Please ask for: Mrs D Johnson
Email: daun.johnson@arun.gov.uk
Telephone: 01903 737762
Our Ref: BR/37/22/PL
Your Ref:
Date: 23rd February 2022

Application for Planning Permission

Development: Change of use from residential care home (Use C2) to a 10 bed House in Multiple Occupation (Sui Generis).
Location: Cordell House Rest Home 120 Victoria Drive Bognor Regis PO21 2EJ

PROPOSED FIRST FLOOR PLAN

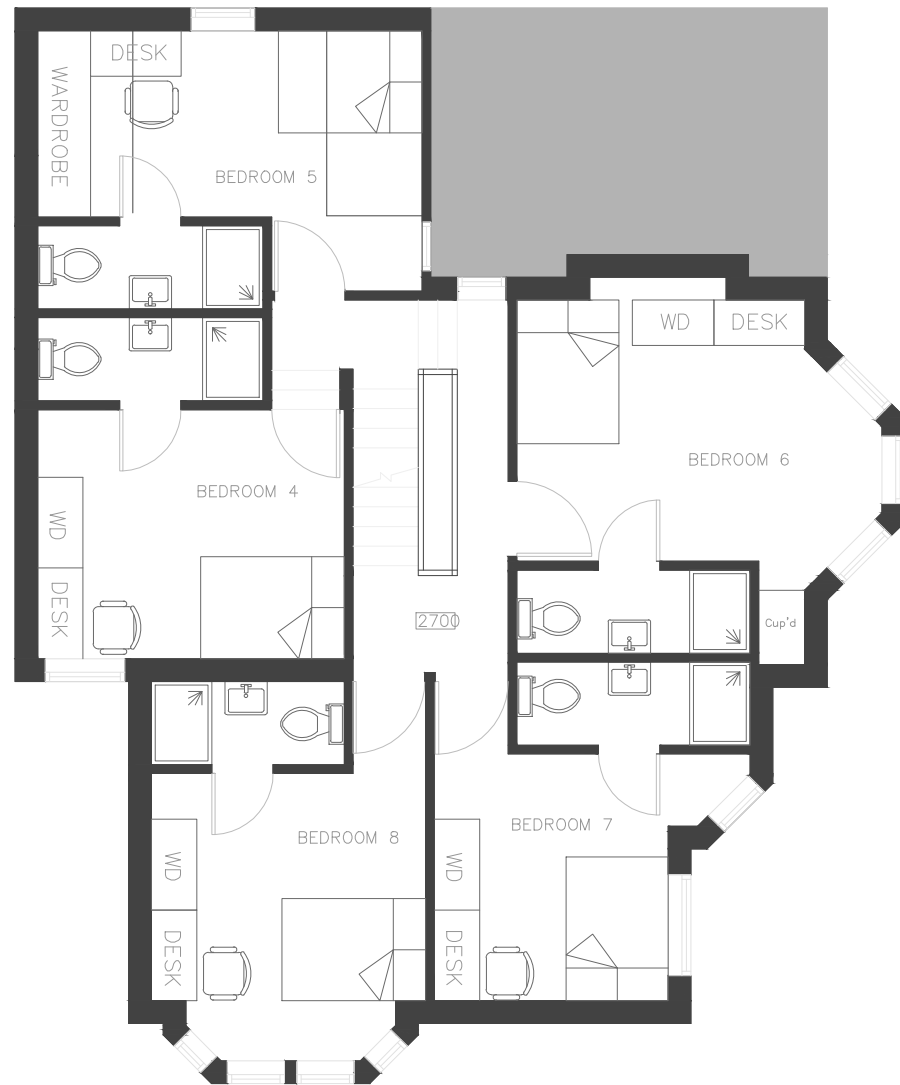
The proposed first floor plan and side elevation do not accord. Please amend accordingly.

PROPOSED SECOND FLOOR PLAN

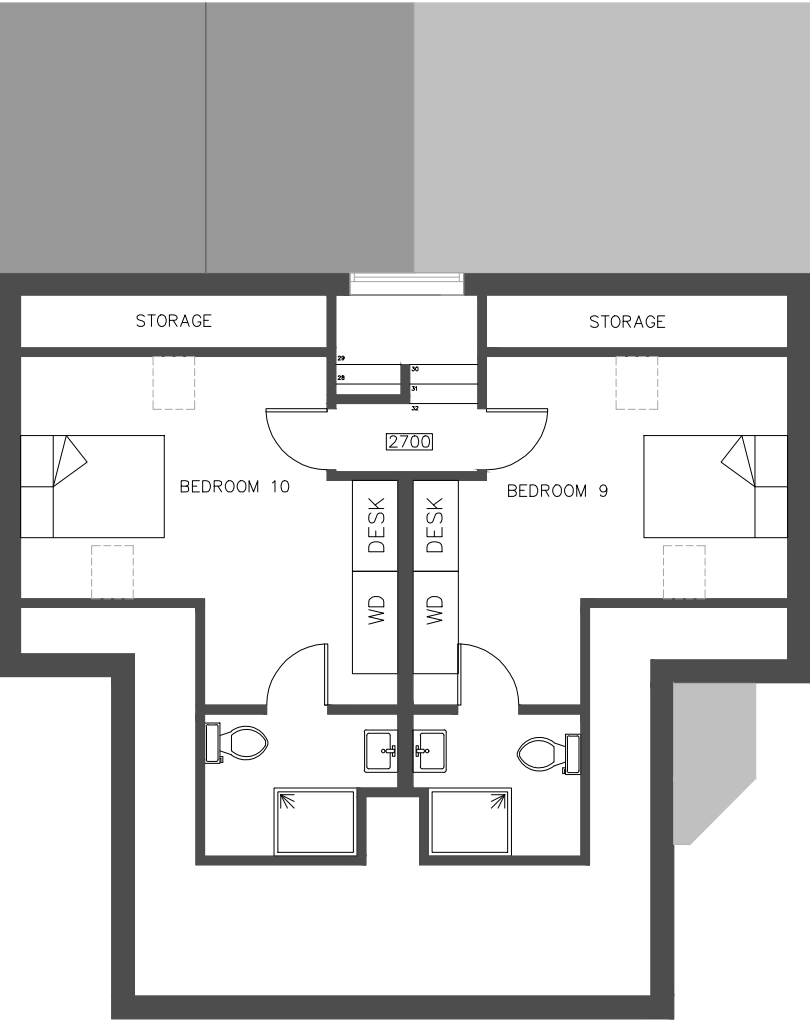
Please clearly show the loft conversion with dormer window to the rear on the proposed second floor plan.

Proposed Elevations

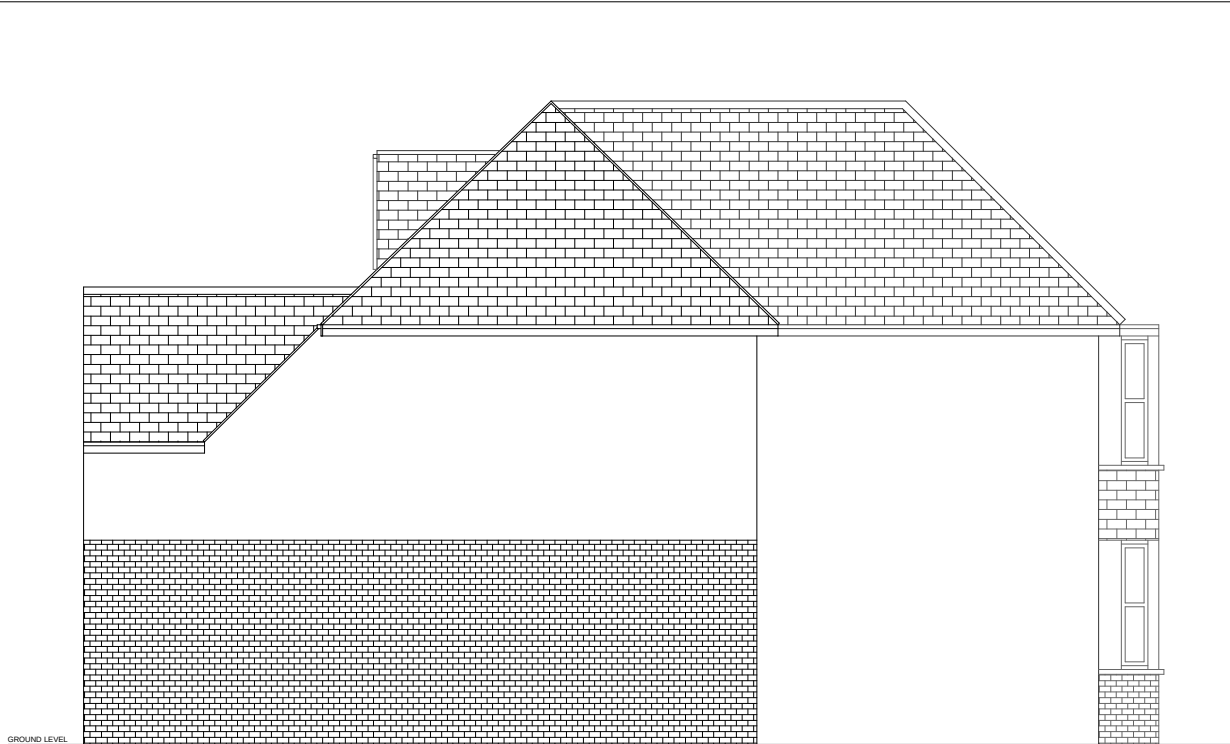
Please provide the existing and proposed other side elevation.
